Recommendation Report for Planning Permission for Works or Extension to a Dwelling

REF NO: WA/16/26/HH

LOCATION: Wickstead House
Binsted Lane
Walberton
BN18 0LN

PROPOSAL: Erection of detached ancillary annexe with habitable roof and installation of air source heat pump. This may affect the setting of a Grade II Listed Building.

2231/41A

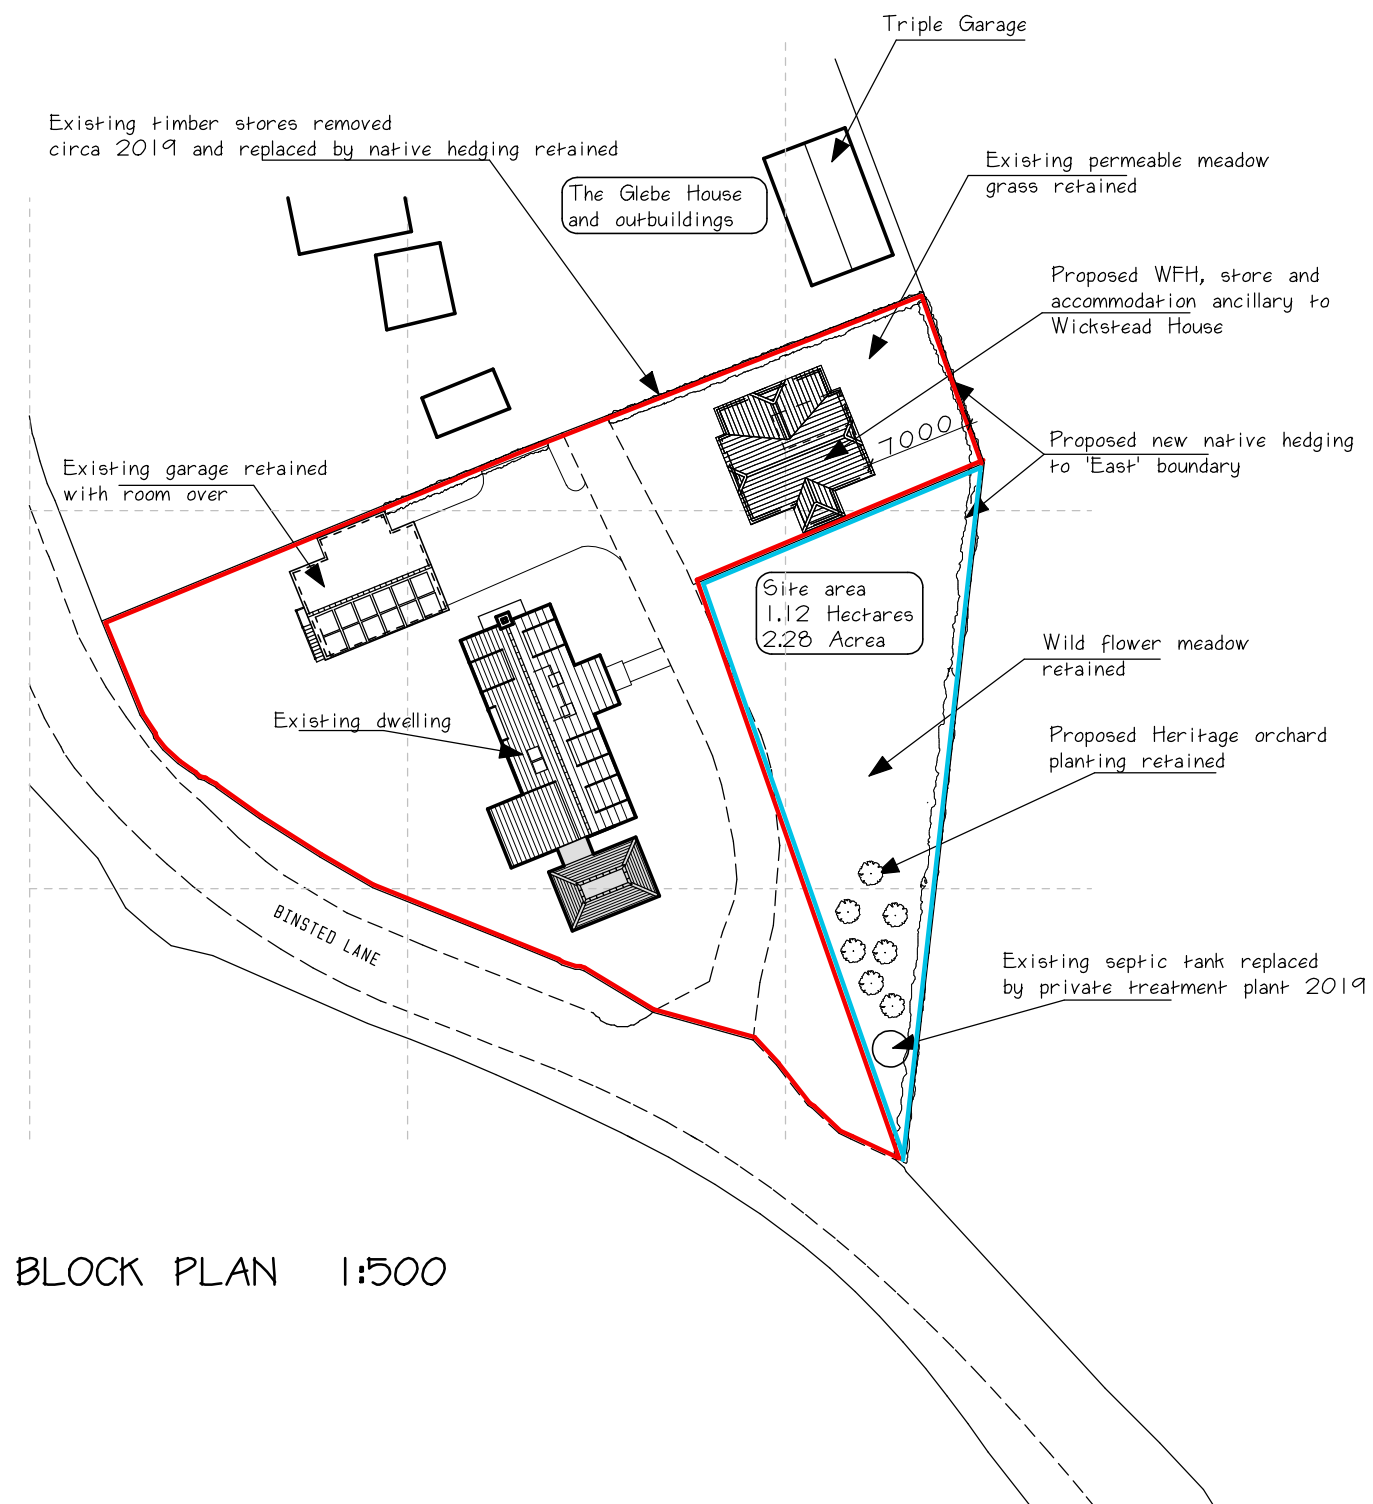
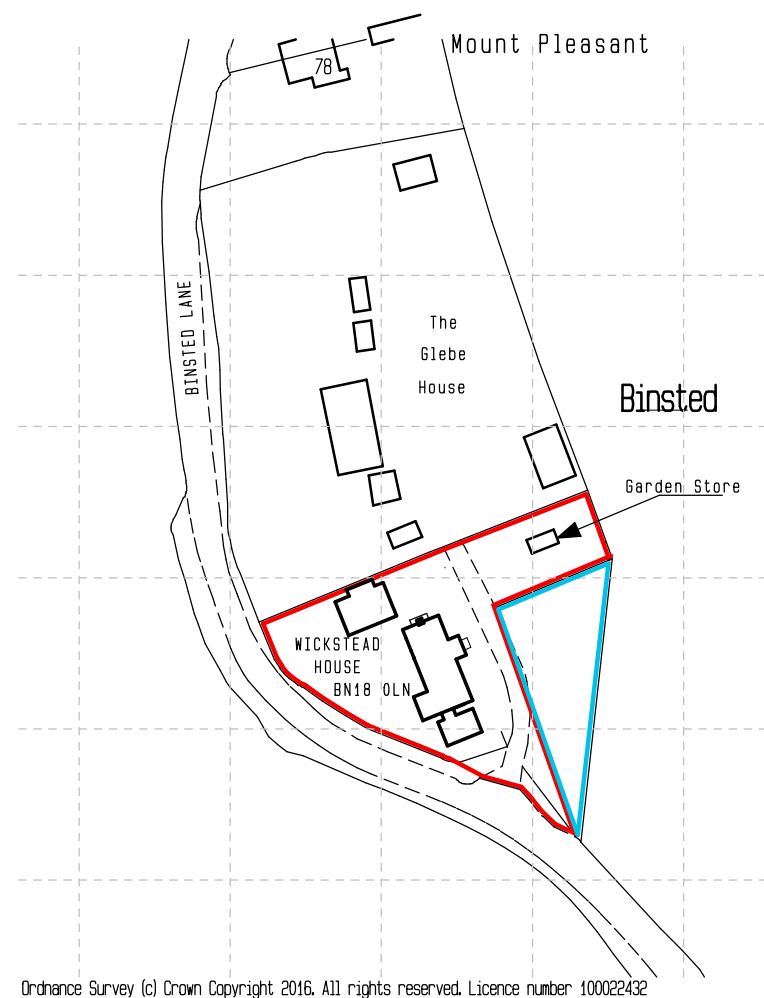
The proposed outbuilding would be set in approximately 1.9m from the northern side boundary with the neighbour, and 7m from the eastern boundary to agricultural land. The outbuilding would be sited at least 18m from the main dwelling of this neighbour and mature vegetation boundary treatment at the shared boundary would result in no overbearing or overshadowing impacts to the neighbouring property.

The ASHP is sited to the rear of the outbuilding, a minimum of 25m away from habitable rooms of the adjacent neighbour. Given the spacing maintained between the ASHP and the neighbouring dwelling, the ASHP would not result in unacceptable noise impacts and is in accordance with Arun Local Plan policy QE DM1.

SOUTH WEST ELEVATION 1:100

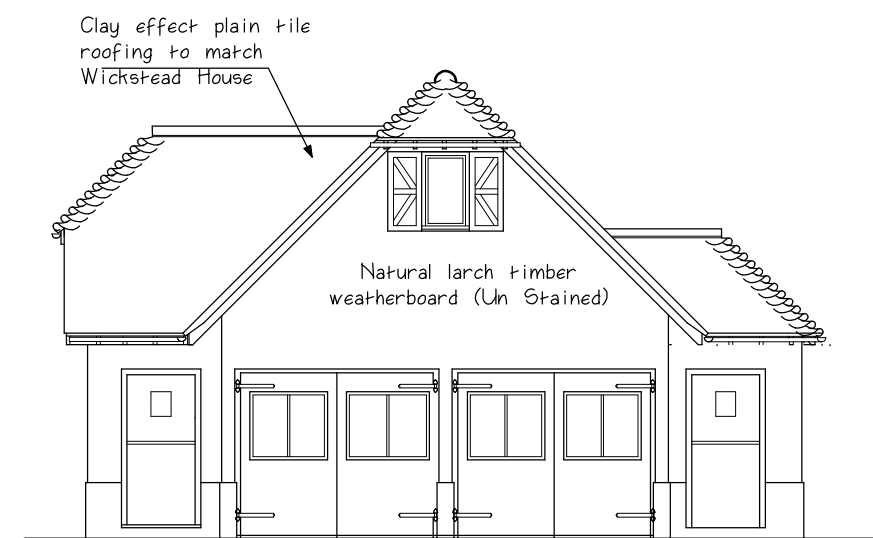
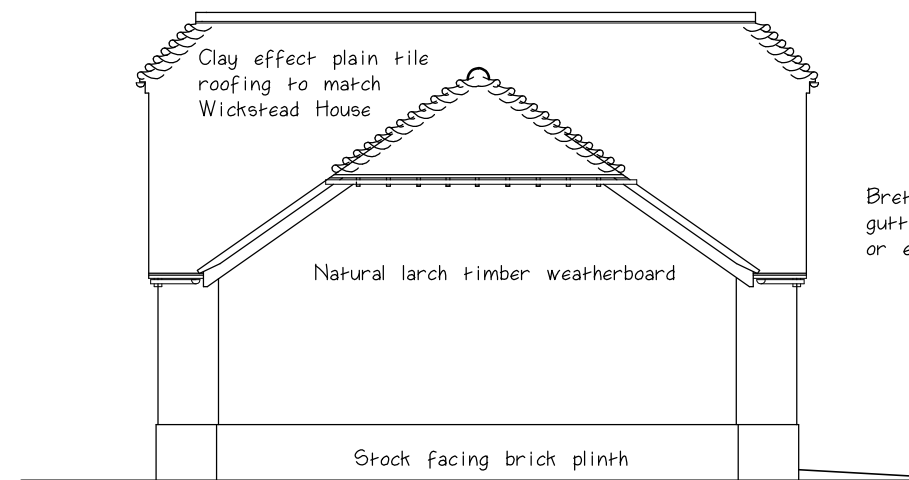
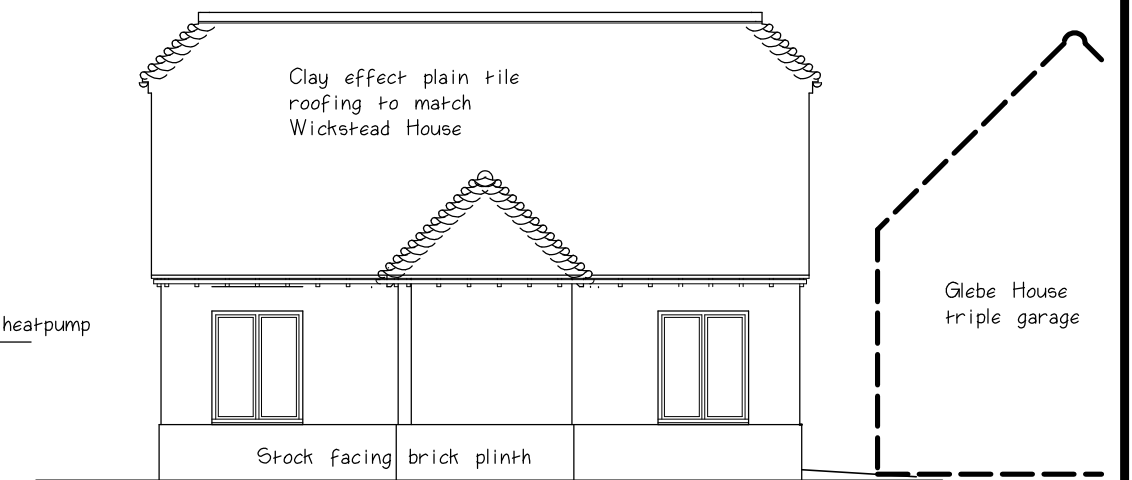
The proposed outbuilding would have a maximum width of 9.5m, maximum depth of 8.5m, an eaves height of 3m, with a maximum height of 6.2m. It would feature two large barn-style doors sealed shut to the south-western elevation, a porch element to the south-eastern elevation, and a barn-hipped side projection to the north-western elevation. An inset balcony is proposed within the north-eastern elevation with timber balustrades, and two patio style doors are proposed within the ground floor of this elevation. The outbuilding would feature a barn-end roof in clay effect tiles as well as unstained timber weatherboarding and brick plinth to the external walls, to match materials present on the main dwelling. The use of matching materials is a sympathetic contribution to the host dwelling and the semi-rural character of the area. The outbuilding although larger in scale than the existing garden store, would appear as an agricultural style ancillary outbuilding, appropriate for its setting and is acceptable in accordance with Arun Local Plan (ALP) policy D DM1.

No fenestration is proposed within the north-west elevation facing the neighbour and any additional fenestration within the outbuilding would not result in adverse overlooking impacts.
